TfNSW reference: STH25/00355

SSD-93649710 (PAE-125152490) - Advice on Environmental Impact Statement (EIS) - Proposed Lowesdale Breeder Farm – LOT 125 DP661622 – 7550 Riverina Highway, LOWESDALE

TfNSW has reviewed the supporting documentation including the Environmental Impact Statement (EIS) and Traffic Impact Assessment (TIA) Report prepared PSA Consulting (Australia) Pty Ltd dated May 2026;

ONE TREE LANE - CONCEPTUAL PLAN

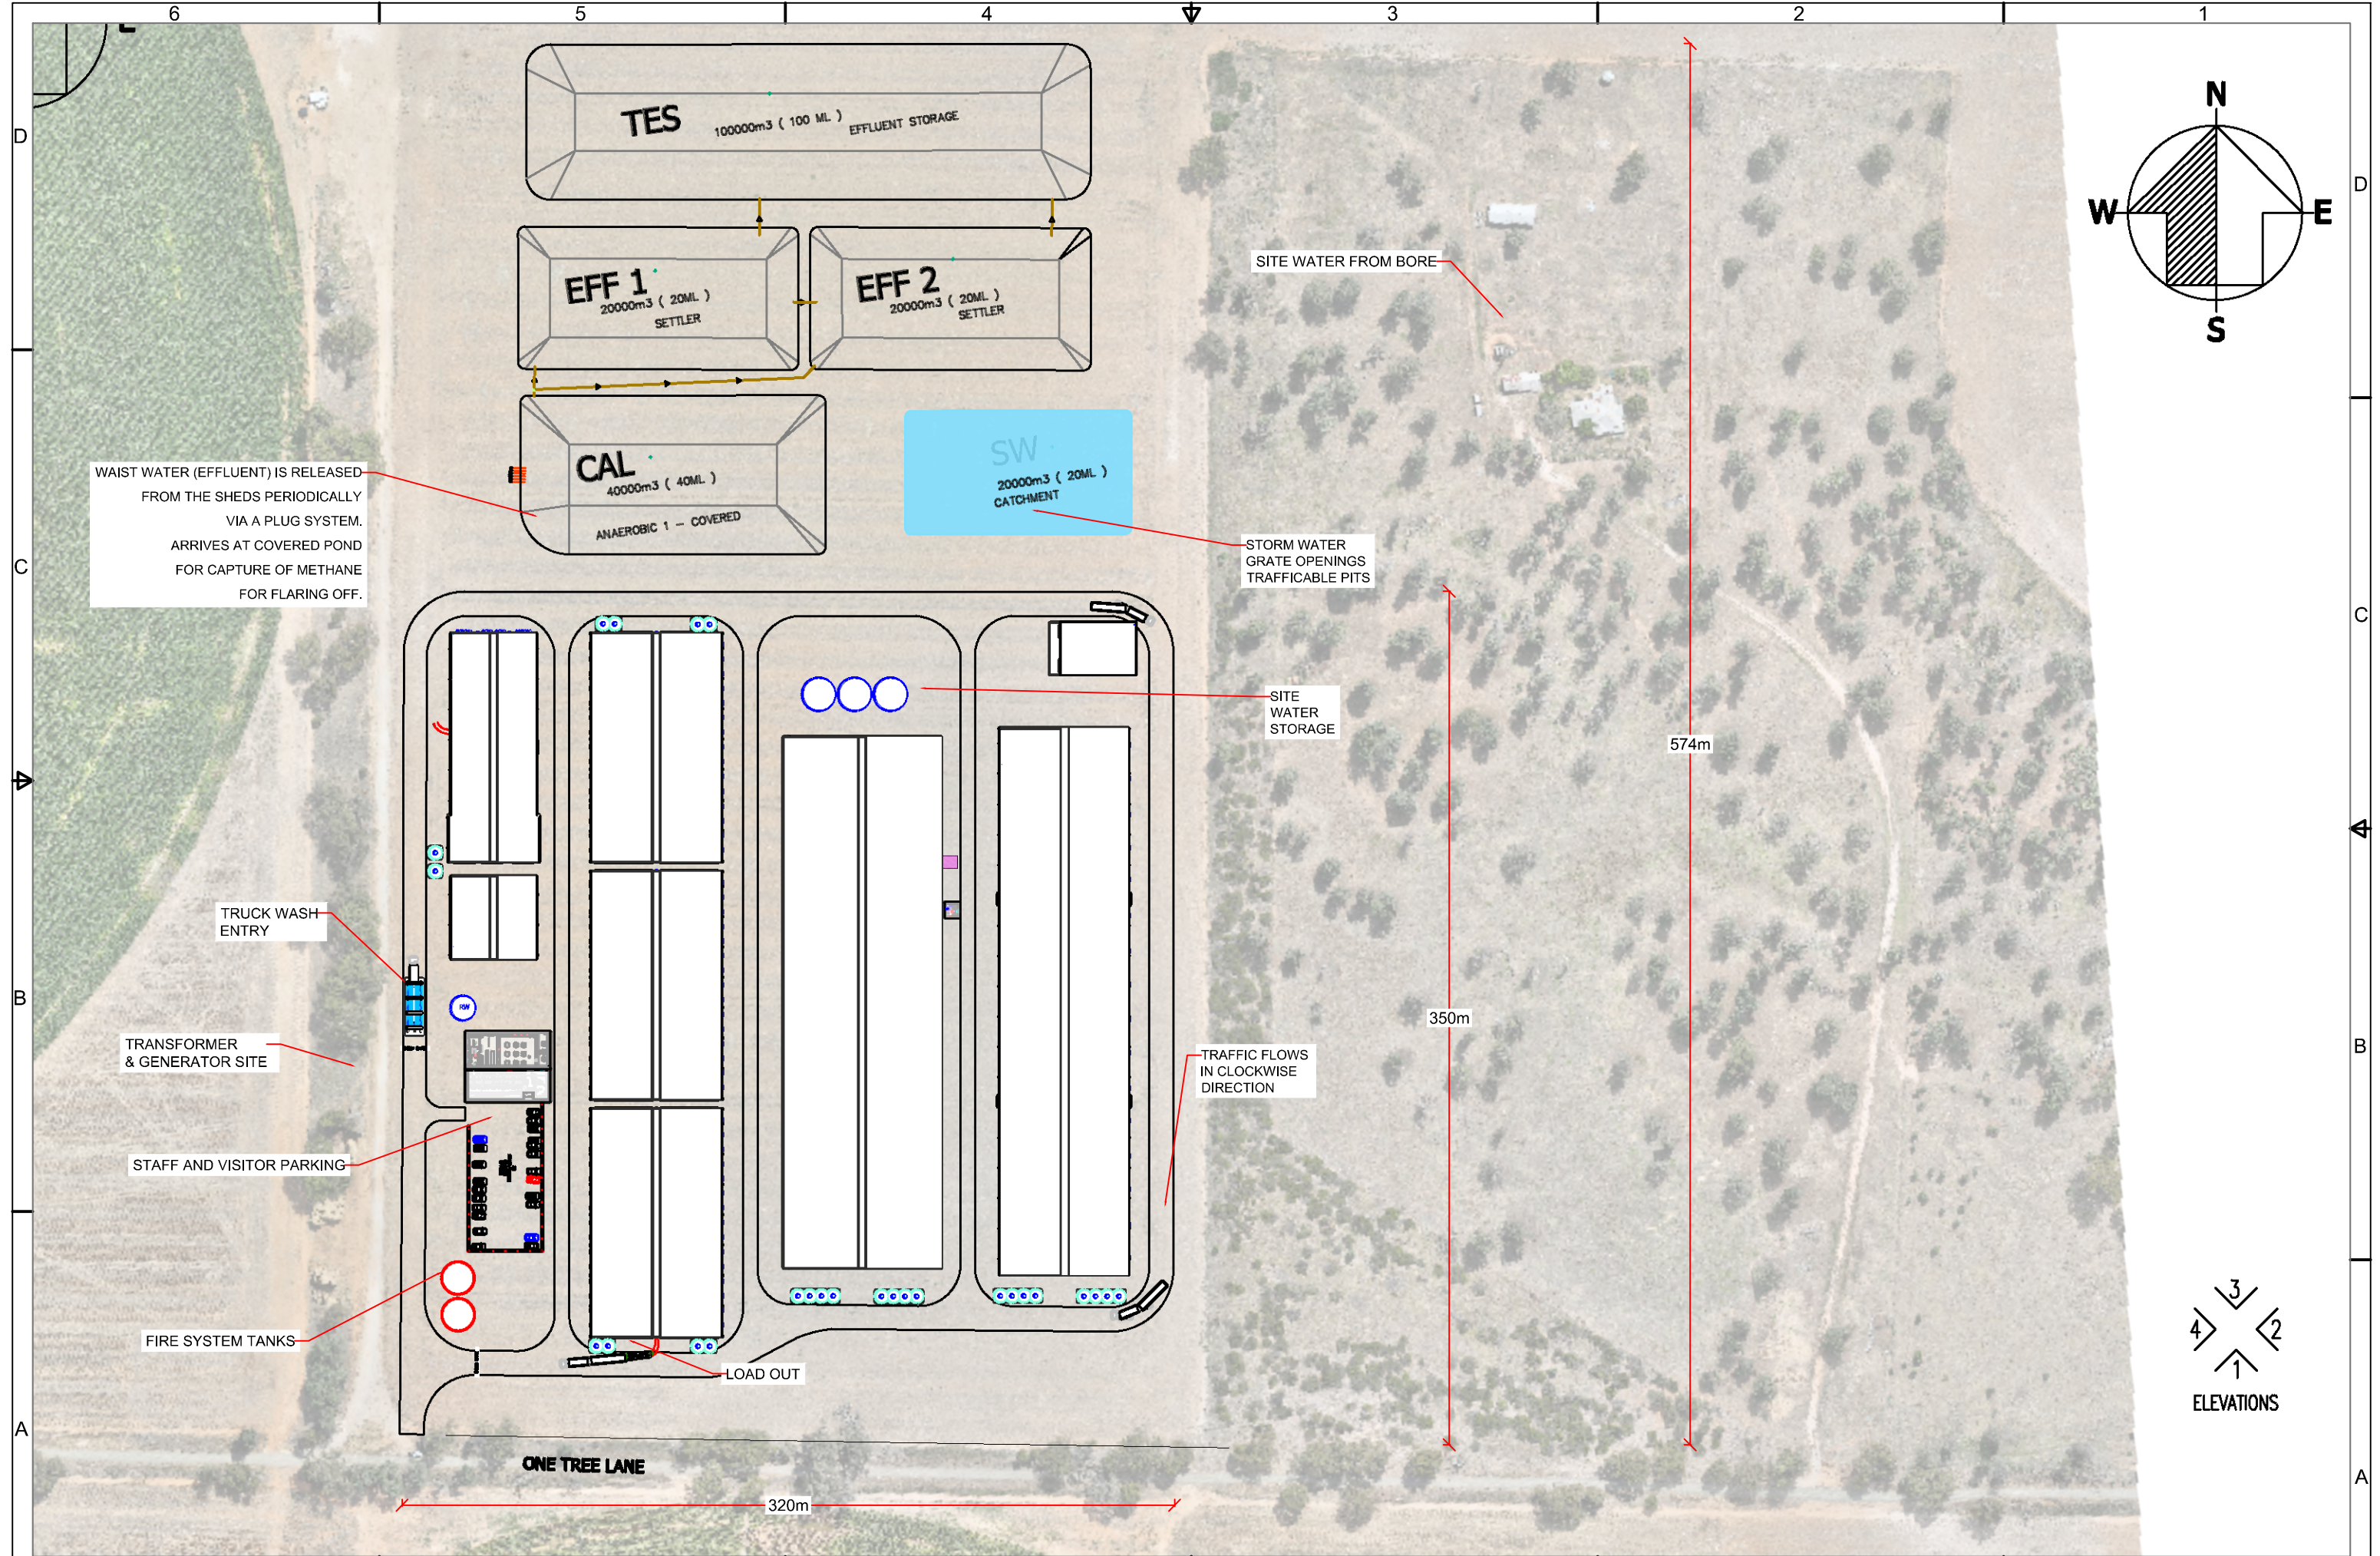
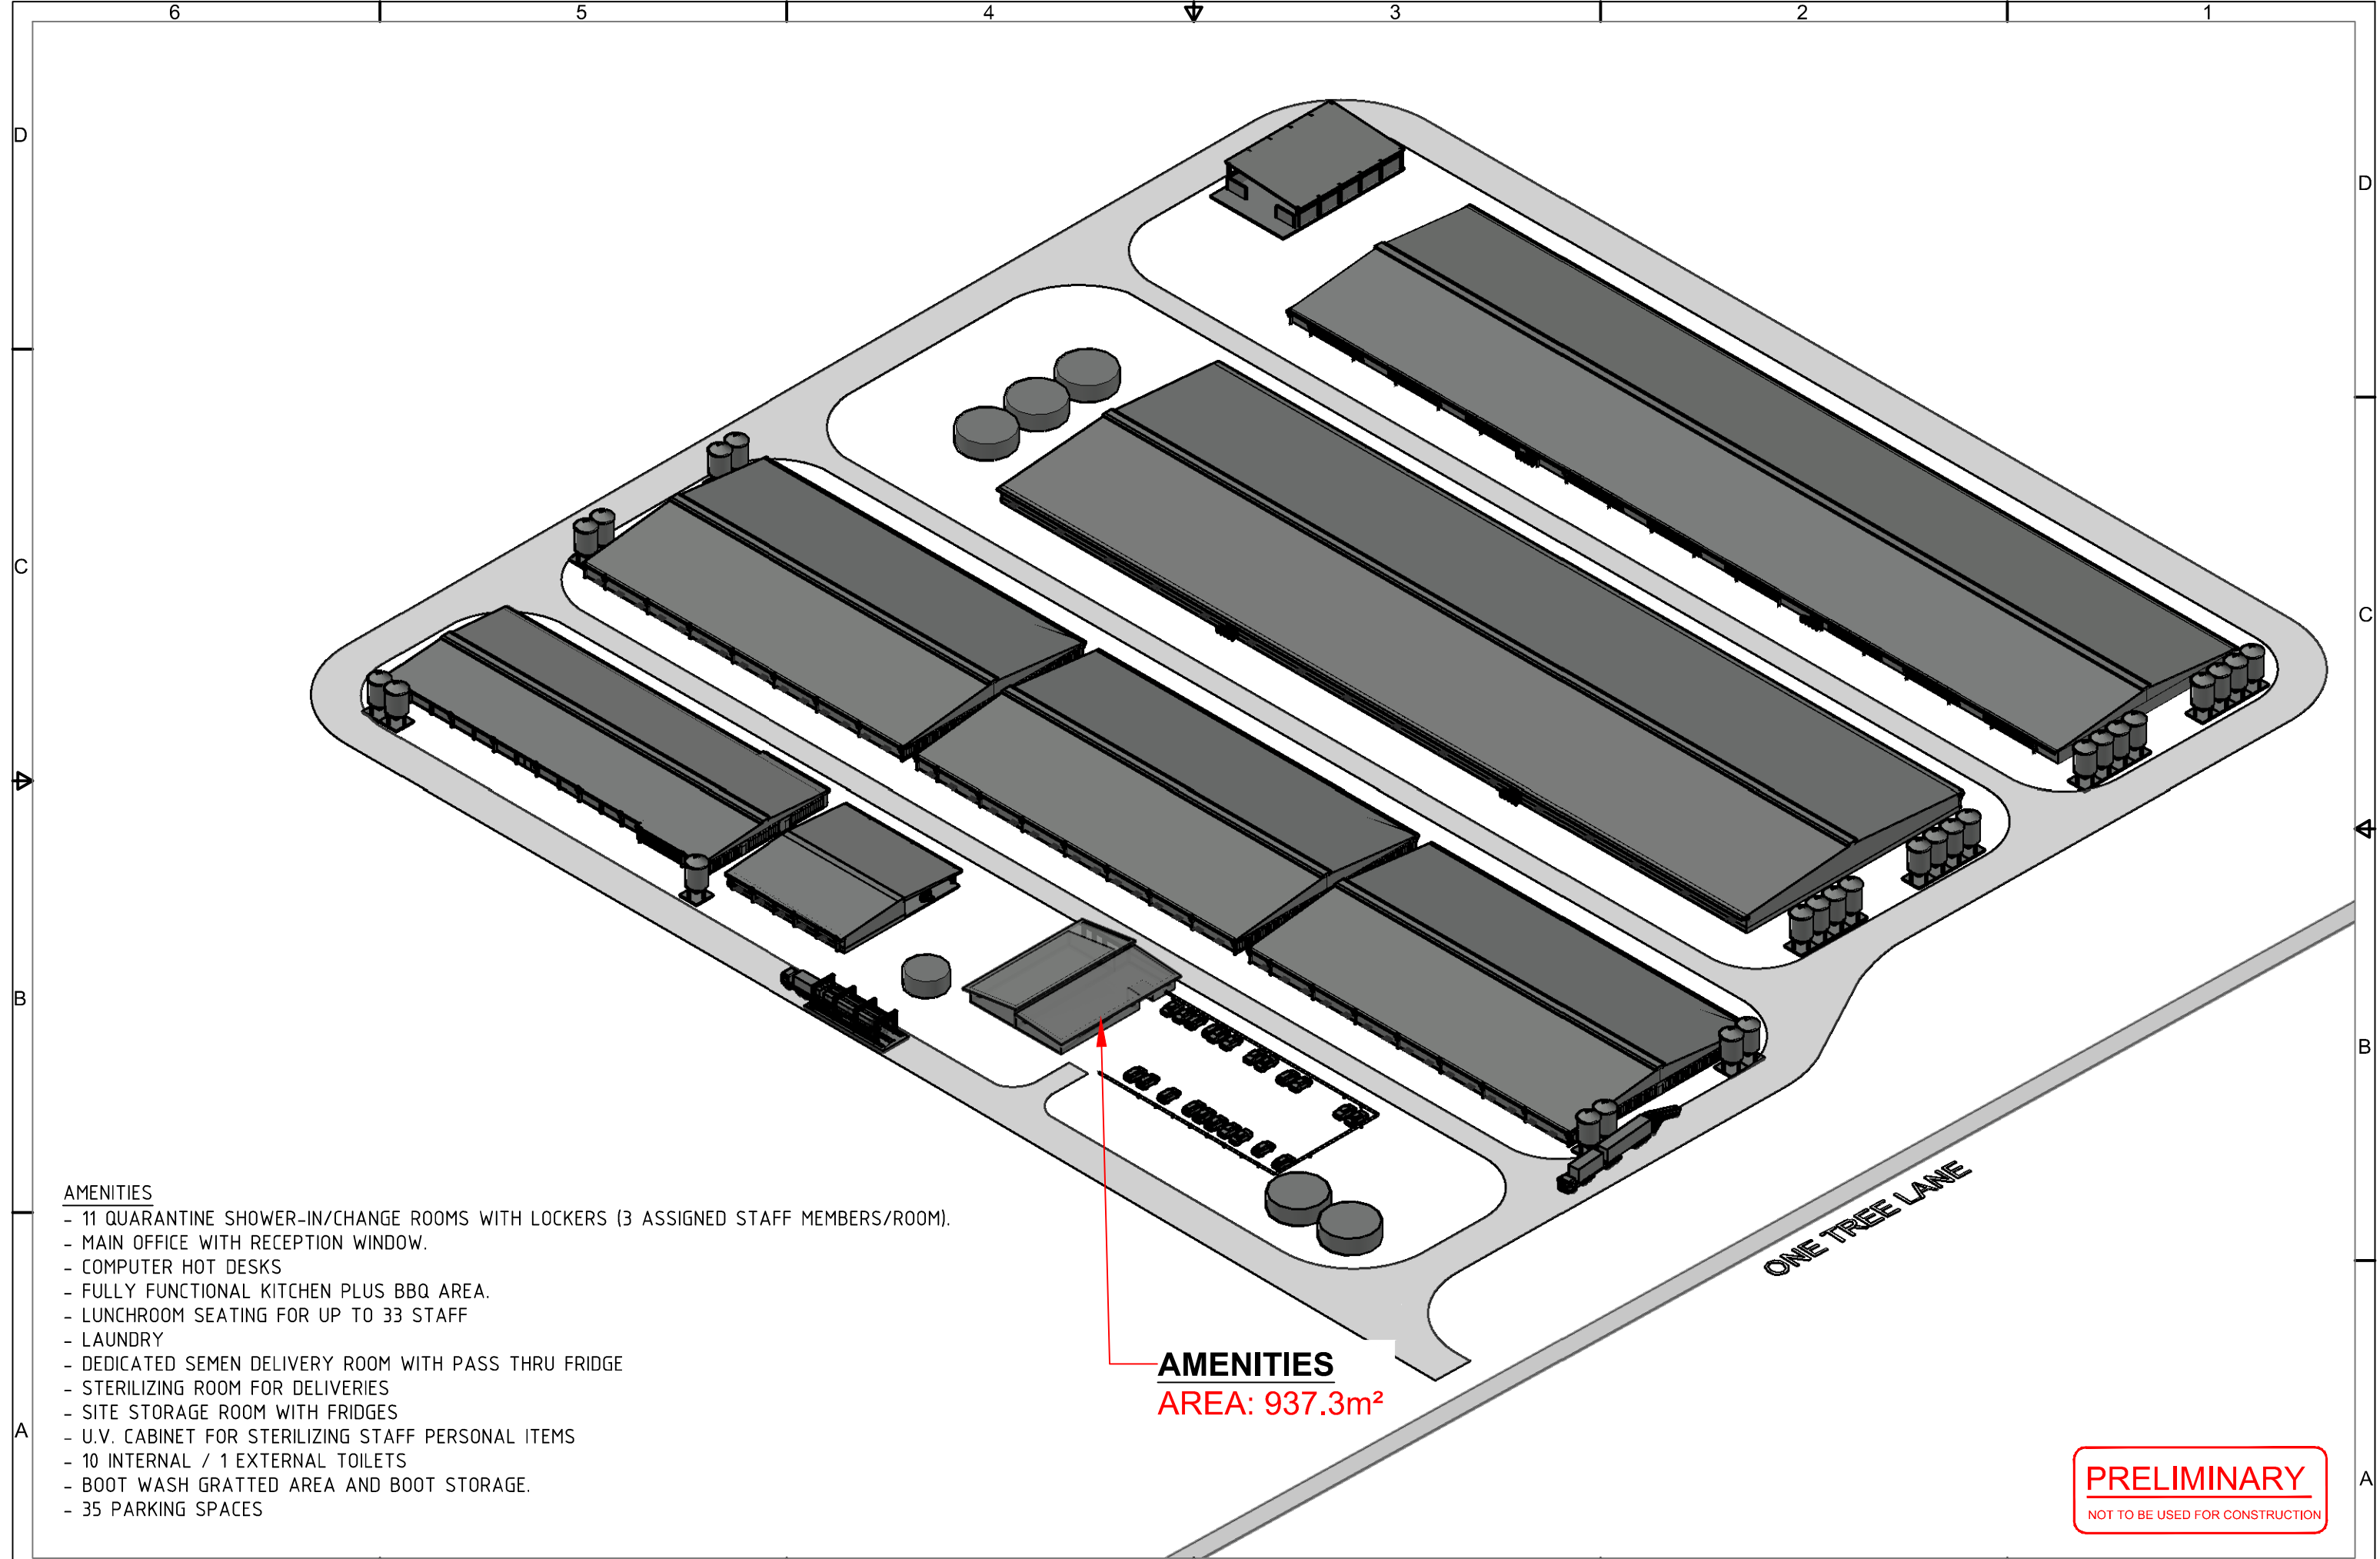
- TfNSW has reviewed the submitted swept paths which form part of the intersection upgrade shown in **Attachment 3**. The swept paths indicate that there will be encroachment cross the One Tree Lane centre line associated with the inbound right-turn movement for a B-Double heavy vehicle. Whilst TfNSW acknowledges the low heavy vehicle movements associated with the development and the visibility at and around the intersection, TfNSW is not satisfied with the encroachment across the One Tree Lane centre line as it poses an unnecessary risk to the safety and efficiency of the classified road network. This will need to be rectified in the required additional information to be submitted with the Response to Submissions (RtS).

The submitted swept paths in **Attachment 3 (INBOUND MOVMENTS)** currently indicates that the B-Double heavy vehicle right turn movement from the Riverina Highway cannot be undertaken without encroaching across the One Tree Lane centre line. This poses an unnecessary risk to the safety and efficiency of the classified road network.

TfNSW **requires an amended strategic design and associated swept paths documentation** which rectifies this issue to form part of a revised TIA and EIS (where applicable) and be submitted with the Response to Submissions (RtS).
